From: Laura Gibbons
Sent: 22 October 2018 08:44
To: Planning.Responses
Cc: Anita Gardner
Subject: RE: Planning Consultation on WA/86/18/DOC

Engineers Comments Regarding Condition 3

Site Address: Ashgrove West Walberton Lane Walberton BN18 0QS

Description of Works: Application for approval of details reserved by condition relating to conditions imposed under planning permission WA/41/18/HH relating to condition No. 3 - Surface water drainage scheme

©	This drawing is the copyright of Robert Clark Associates Limited It may not be copied or reproduced without their written authority		
Scale	As shown	At original	A3
Drawing Number	1900/SK2		Revision -

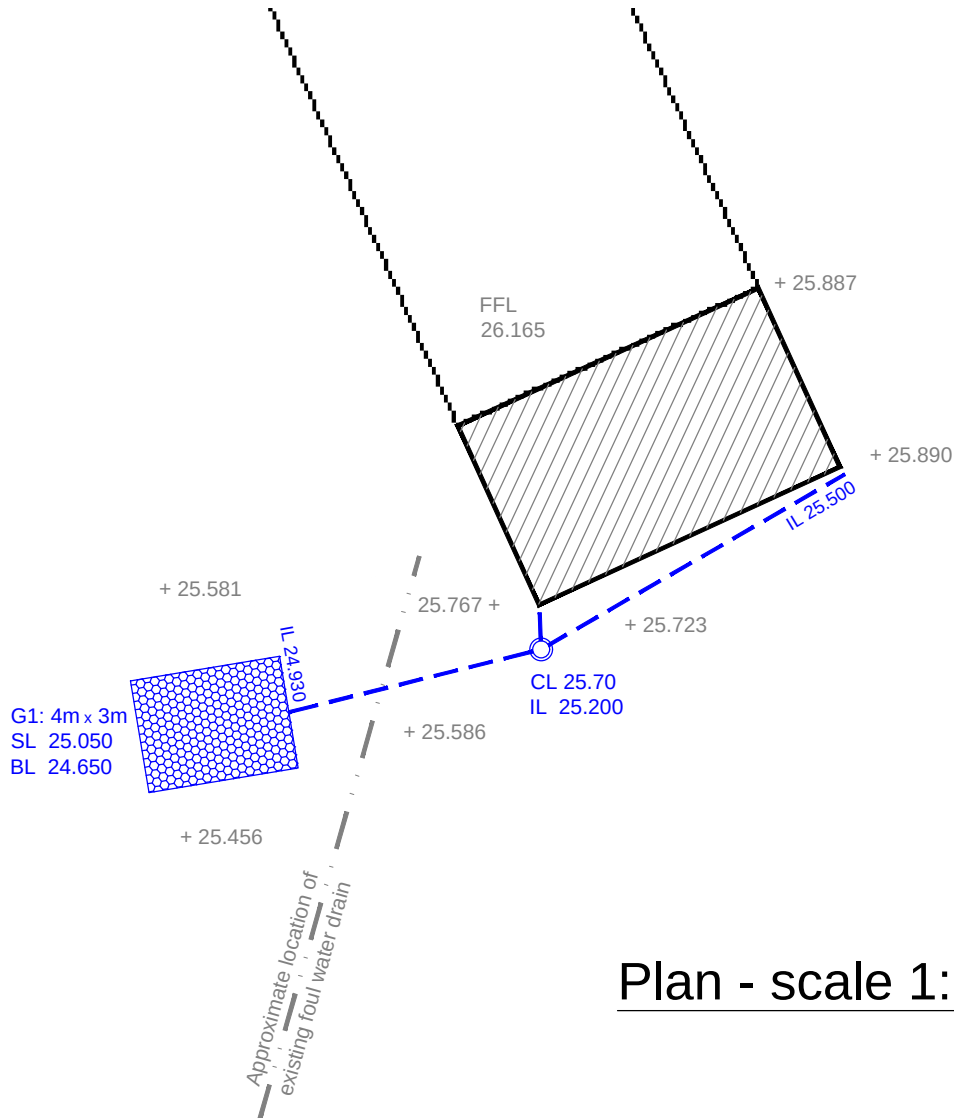
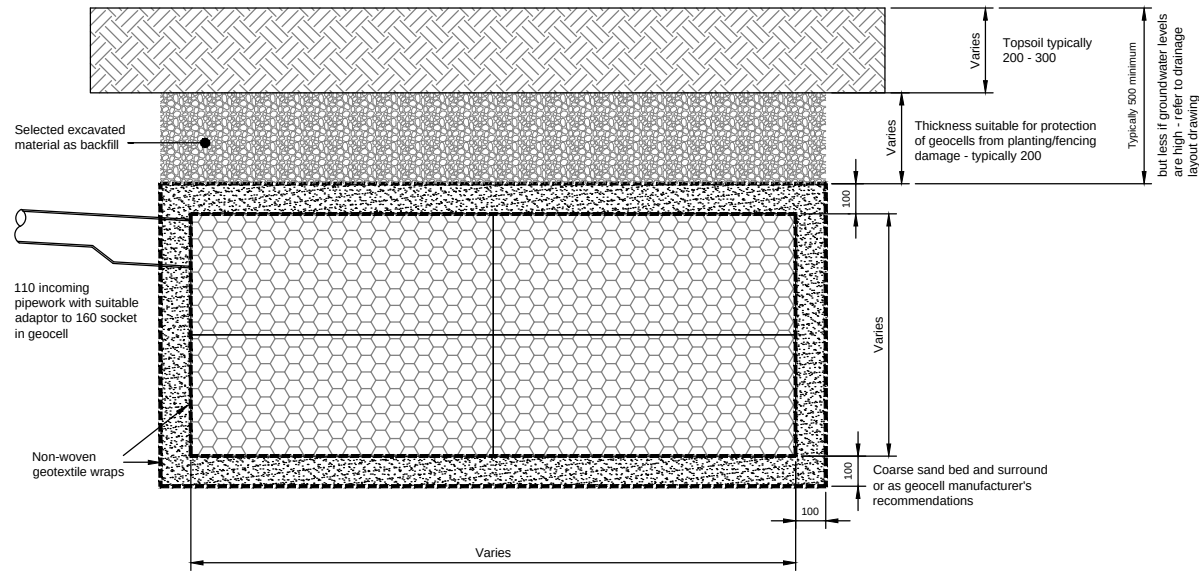
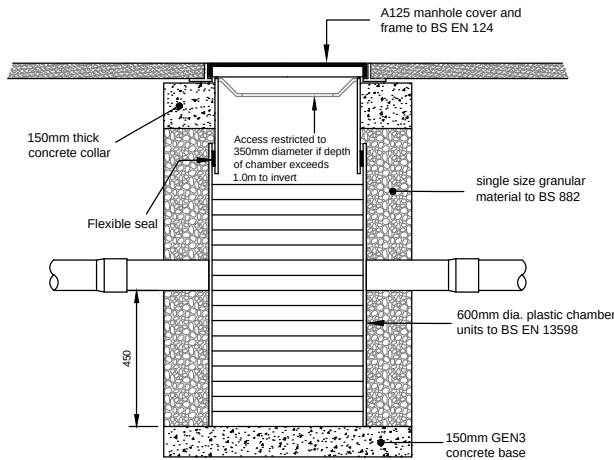
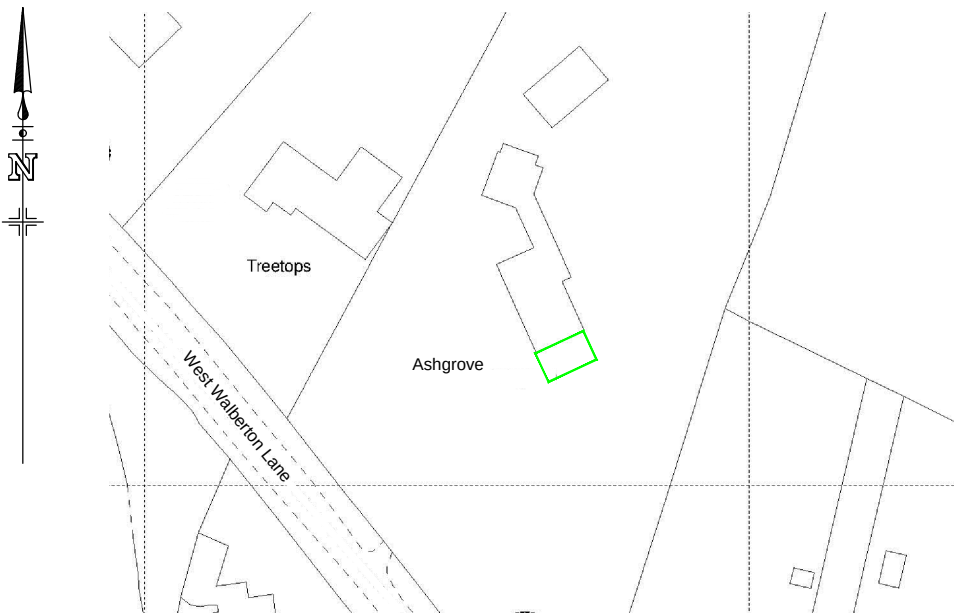
No winter groundwater monitoring or infiltration testing has been completed. West Walberton Lane has a history of flooding so it is very important to get the surface water design correct. I therefore recommend that this condition is not discharged.

Please carry out the appropriate monitoring in January or February.
